**REQUEST**

Proposed Zoning: I-1(CD) AIR LLWPA (light industrial, airport overlay, Lower Lake Wylie Protected Area)

Approximately 13.22 acres located on the north side of Business Center Drive and Interstate 85 and west of Little Rock Road.

**SUMMARY OF PETITION**

RZ  
 1

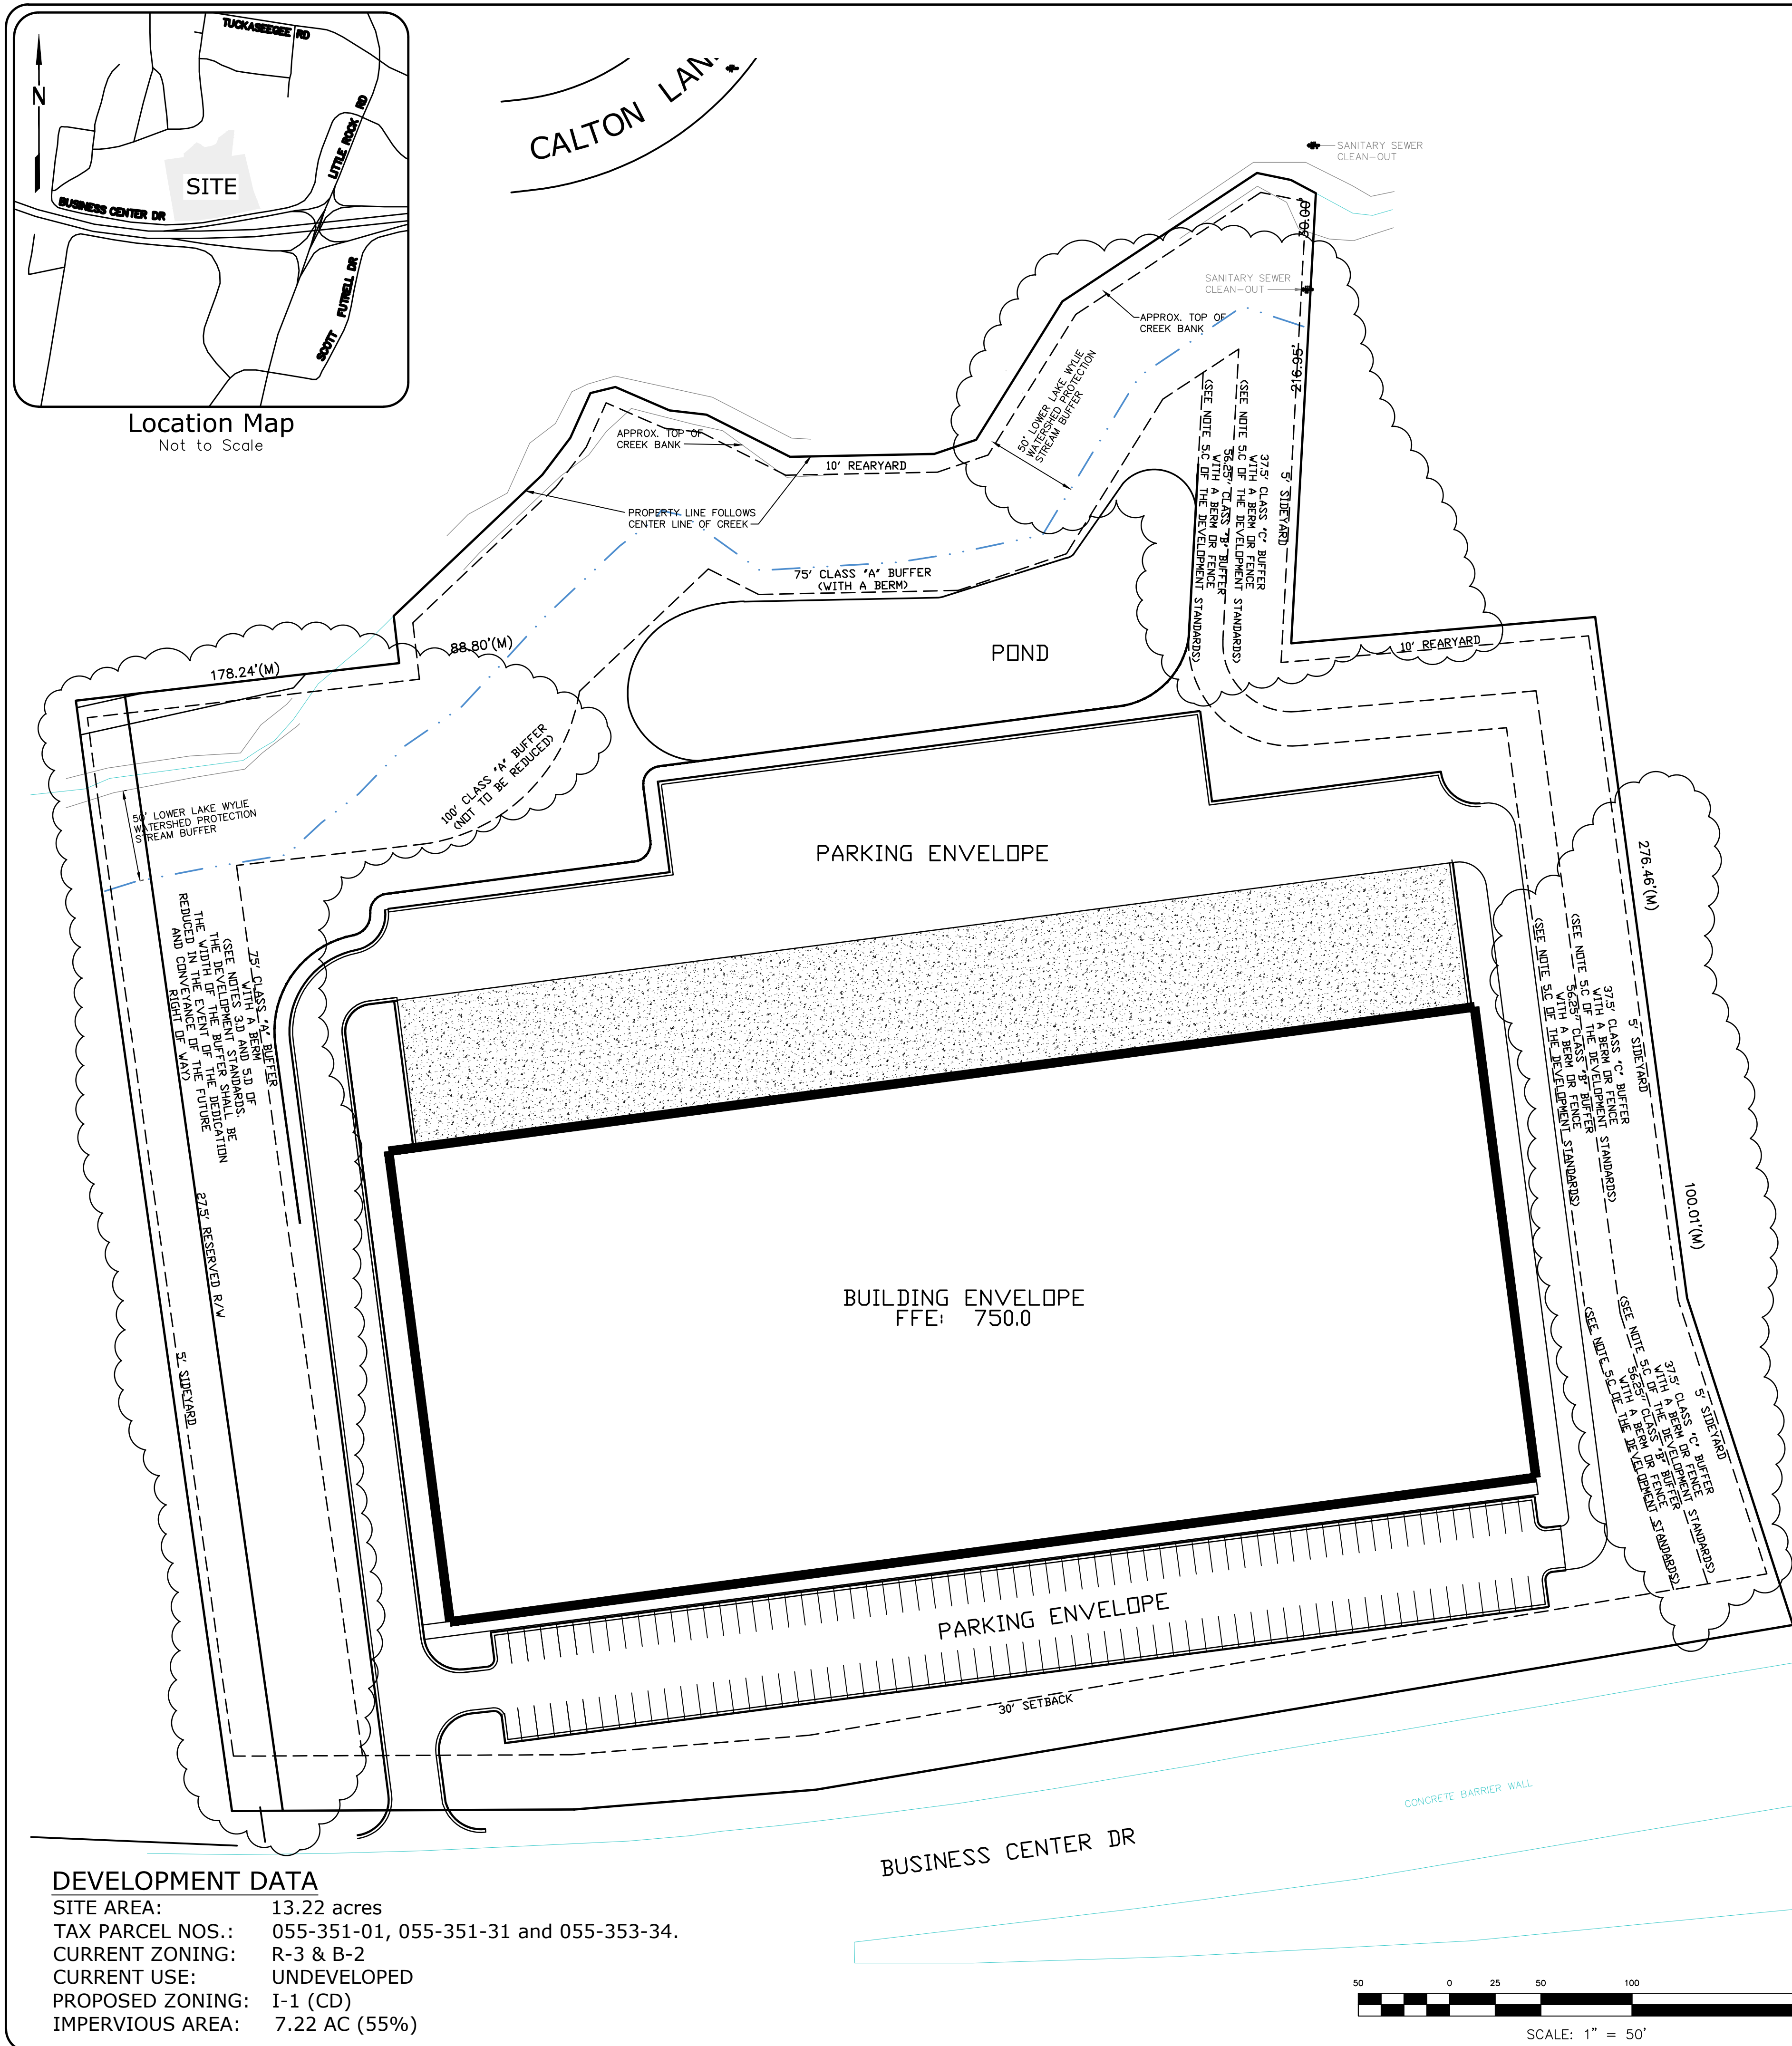
- ~~1. Revise the site plan and conditional note(s) to commit to dedicate right of way 2 ft back of sidewalk on Business Center Drive, labeled and dimensioned from the road centerline. ADDRESSED~~
- ~~2. Revise the site plan and conditional note(s) to commit to construct an 8-foot planting strip and a 6-foot sidewalk along the site's Business Center Drive frontage, per Charlotte WALKS, labeled and dimensioned from the road centerline. ADDRESSED~~

- ~~3. Stream buffers are incorrectly labeled. Applicability of stream buffer requirements will depend upon stream classification ("intermittent" stream will require 35' PCSO Buffer; "perennial" stream will require 100' watershed buffer). For purposes of advancing the rezoning process, show and label "Potential 35' PCSO Stream Buffer" and "Potential 100' Undisturbed Lower Lake Wylie Watershed Protection Stream Buffer" on the rezoning plan OR provide stream delineation report confirming no intermittent or perennial stream exists (report subject to review and approval by City). ADDRESSED~~

- ~~4. Add the following note under the ENVIRONMENTAL FEATURES heading:  
"Development within any PCSO/Watershed Protection Stream Buffer shall be coordinated with and subject to approval by Charlotte Mecklenburg Storm Water Services and mitigated if required by City ordinance. Petitioner acknowledges intermittent/perennial stream delineation reports are subject to review and approval upon submission of development plans for permitting and are not approved with rezoning decisions." ADDRESSED~~

- ~~5. Label zoning of all adjacent parcels. ADDRESSED~~
- ~~6. Relocate the berm on the western property line to be outside of the reserved right of way. If future right of way is dedicated, a half buffer (50') is required and can be reduced 25% per ordinance with a berm. ADDRESSED~~
